## **Biofuelwatch's comments in response to "REP7-017" The Applicants responses to issues raised at deadline 6**

Drawing file: published-documents / EN010120-000152-6.2.6.12 Drax BECCS ES Vol 2 Figure 6.12 Annual Nitrogen Deposition Maximum Impacts (Baseline).pdf

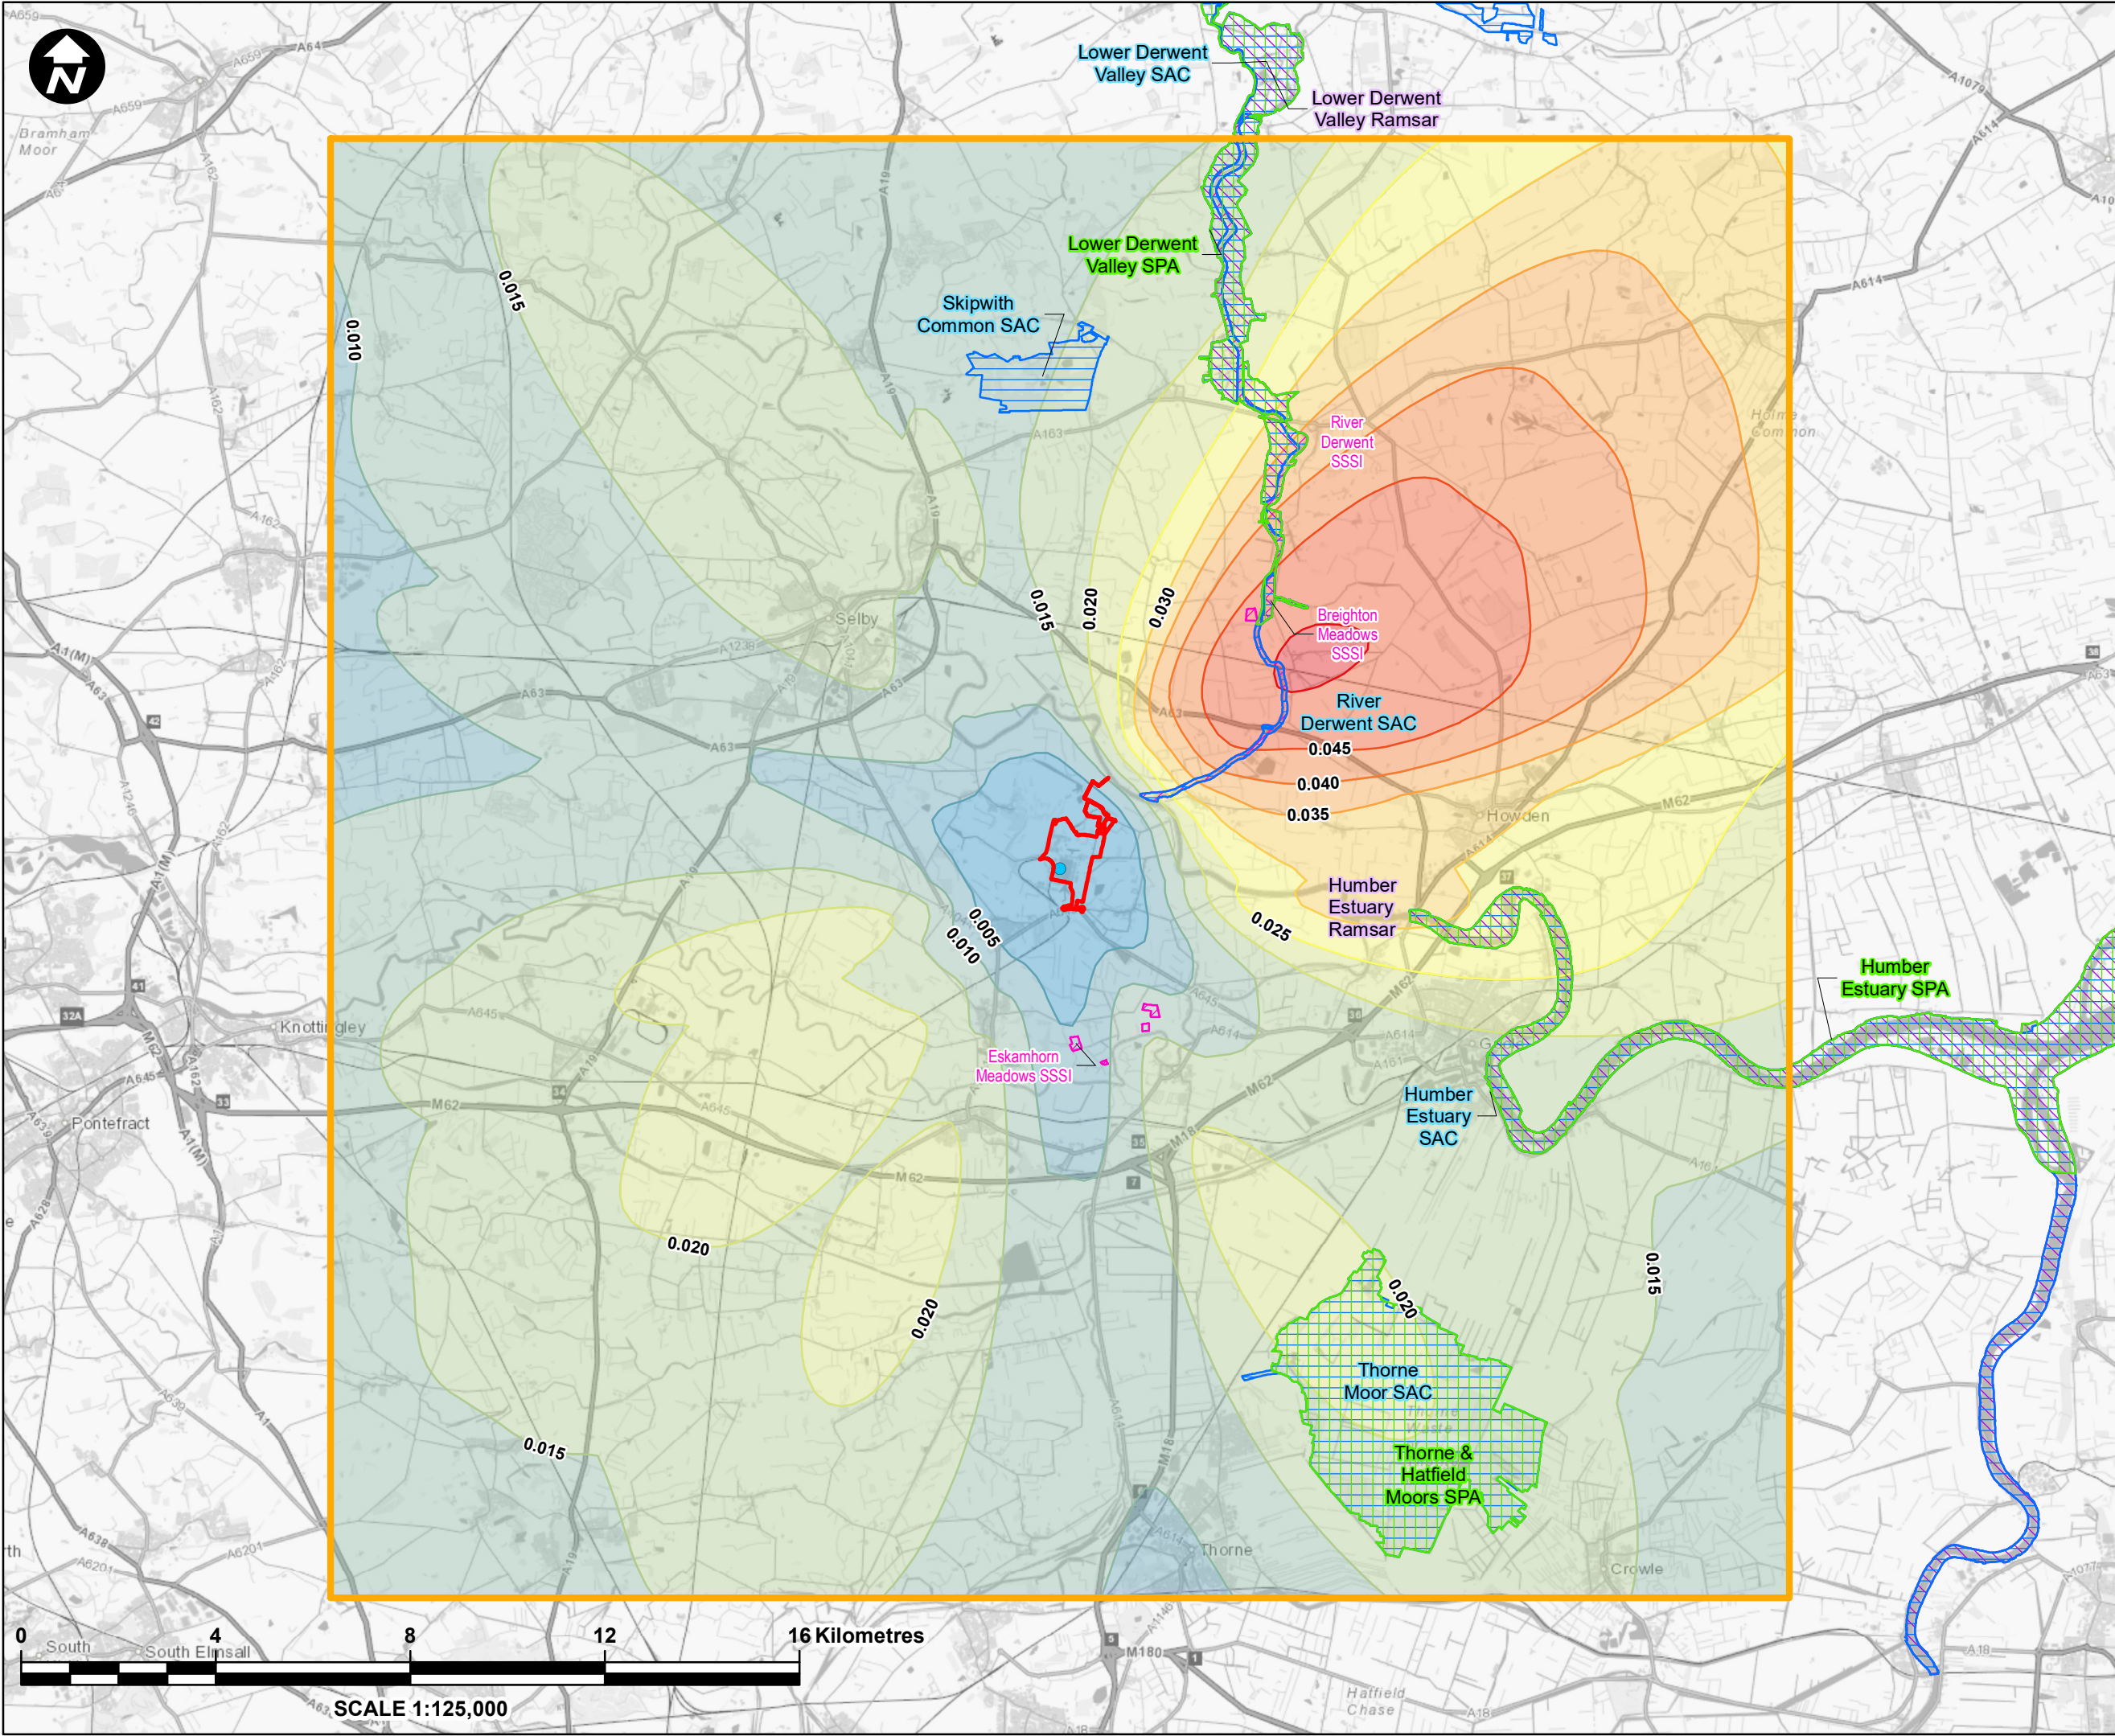
If the peak concentration is only just within the figure then that suggests that there may be important impacts outside the figures. The Norwegian study found slight declines after 10km, but Drax's emissions can be expected to disperse further because of its higher stack. The "slight decline" after 10km, suggests a considerably larger area than 15km, which only just includes the peak concentration, it should be modelled and shown in order to consider impacts on the wider area, such as near Keadby3.
